Project # 1007313

Project Name: BOSQUE PLAZA SUBDIVISION

DATE: July 28, 2008
TO: Jack Cloud, DRB Chair
FROM: Catalina Lehner, Senior Planner *cll*
RE: Project #1007313, Bosque Plaza Office Building

**SITE DEVELOPMENT PLAN FOR BUILDING PERMIT**  
 1" = 10'  
 SITE LEGAL = LOT 3, BOSQUE PLAZA SUBDIVISION, .5161 ACRE

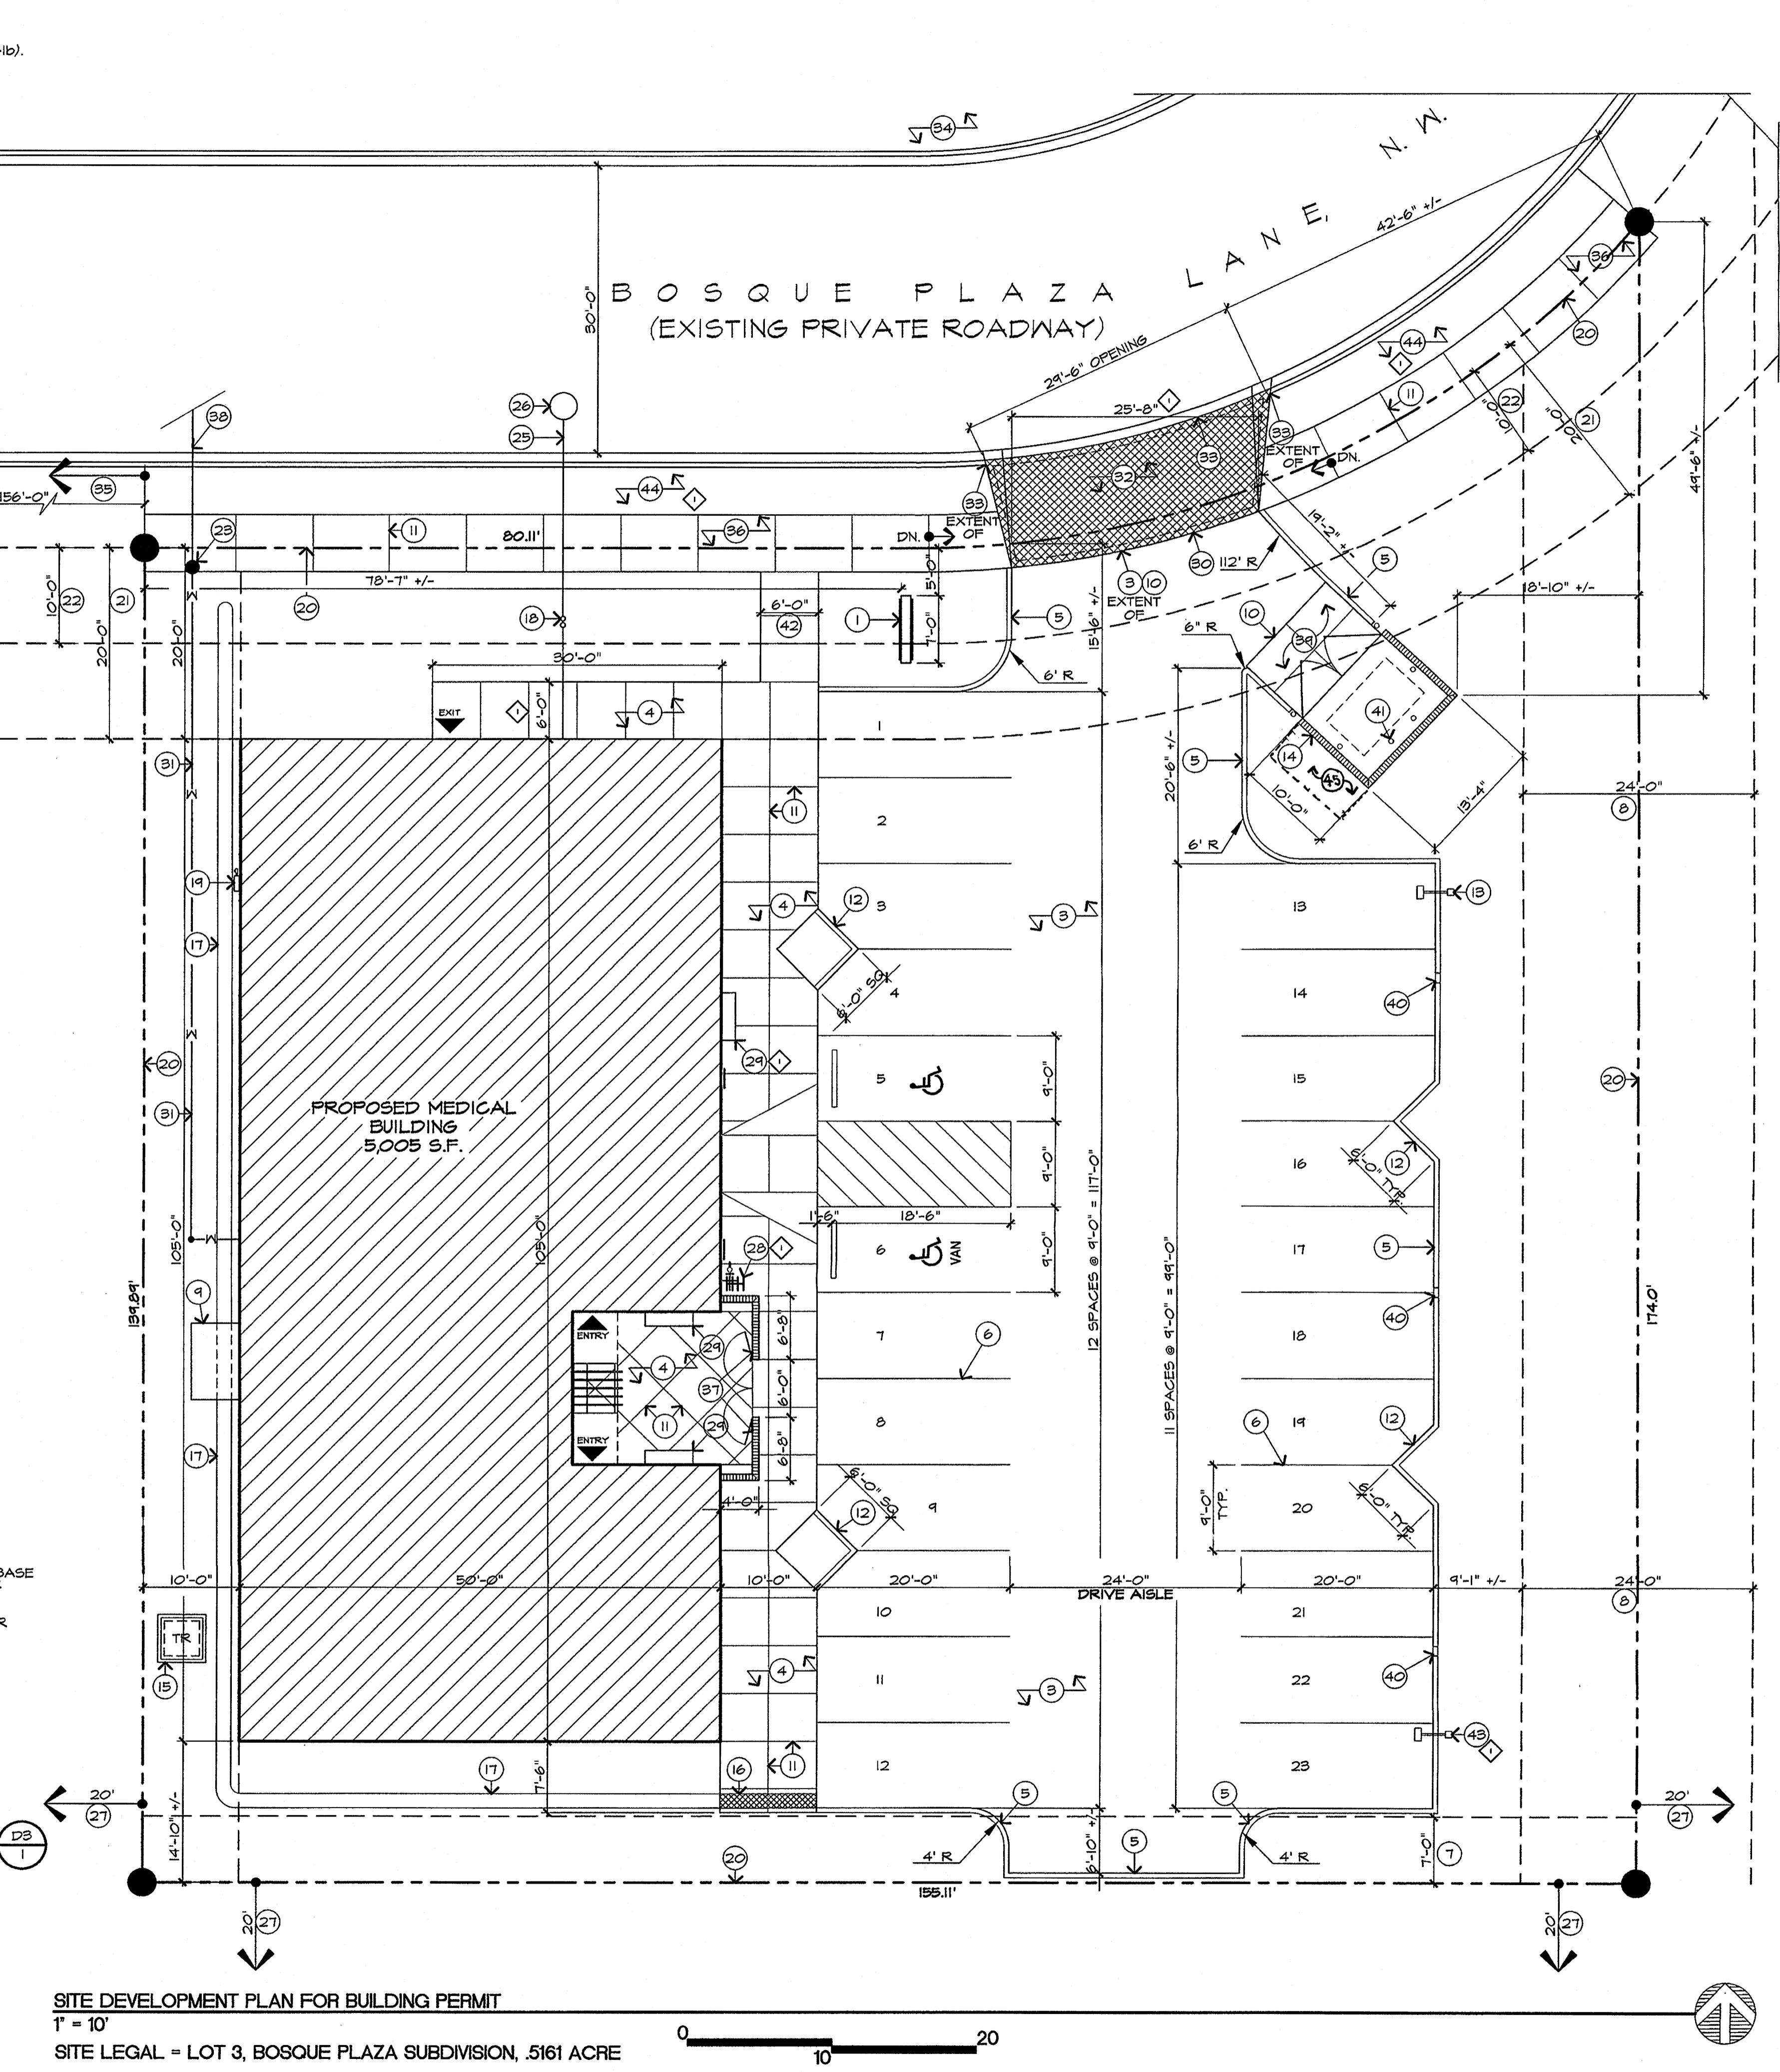
→ PLANNING (Last to sign): add Fire Hydrant, move
sewer service, sign after 8-1-08

**LANDSCAPE PLAN**  
1" = 10'

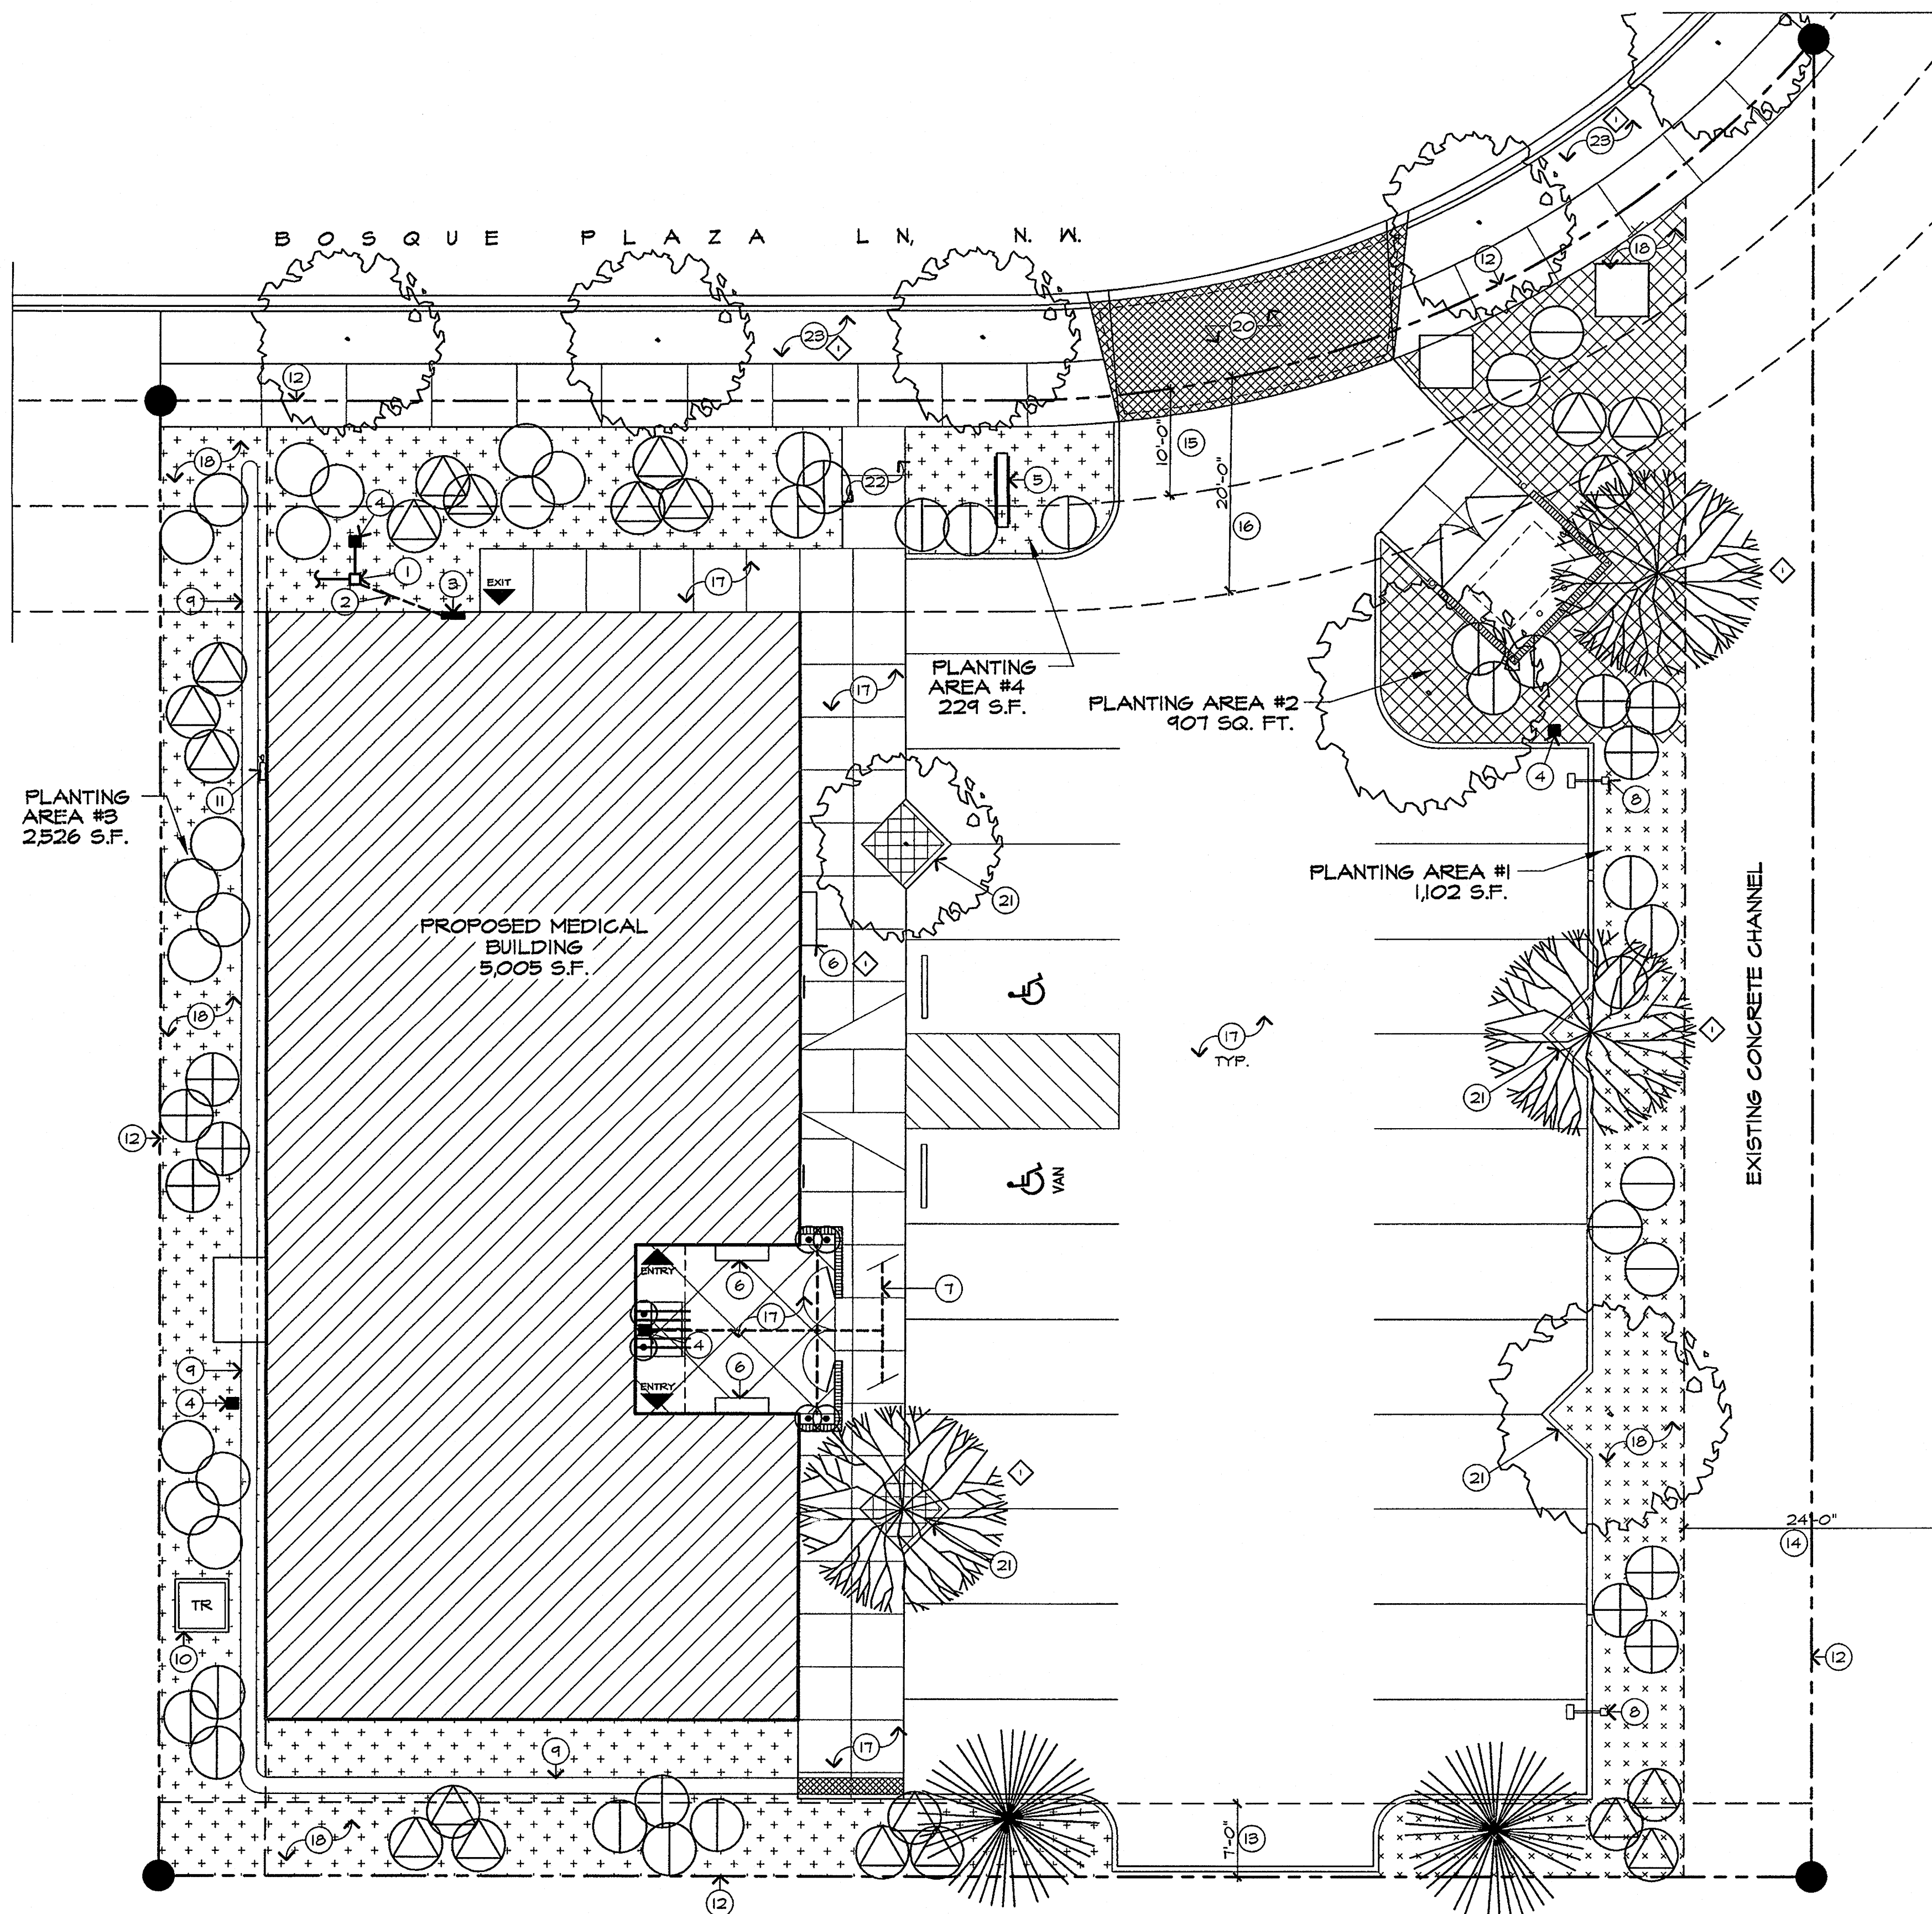
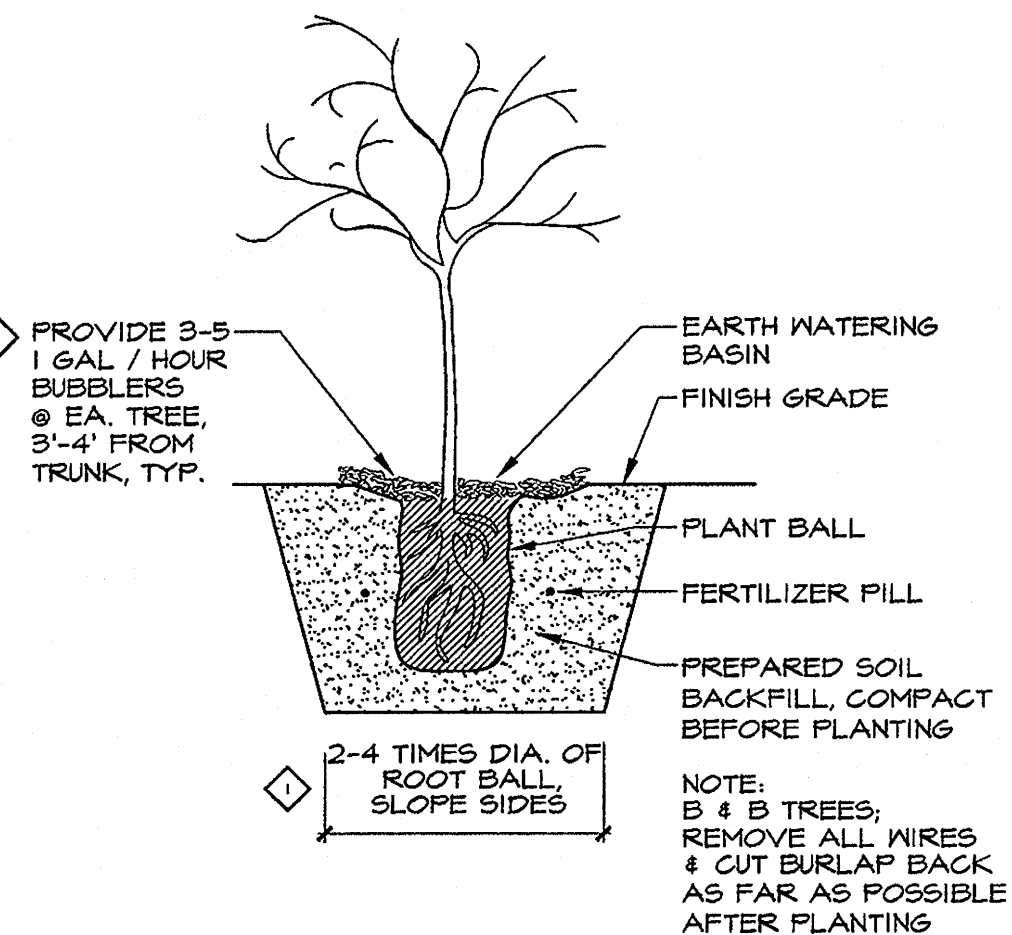
- Condition 7B-Lighting: The applicant has voluntarily lowered the light pole height to 14 ft. instead of 16 ft. as indicated. The 14 ft. is preferable for the nearby homes.
- Landscaping Plan: Add a keyed note #24 to match keyed note #40 on Sheet 1, to indicate the 12 inch curb breaks for water reuse.
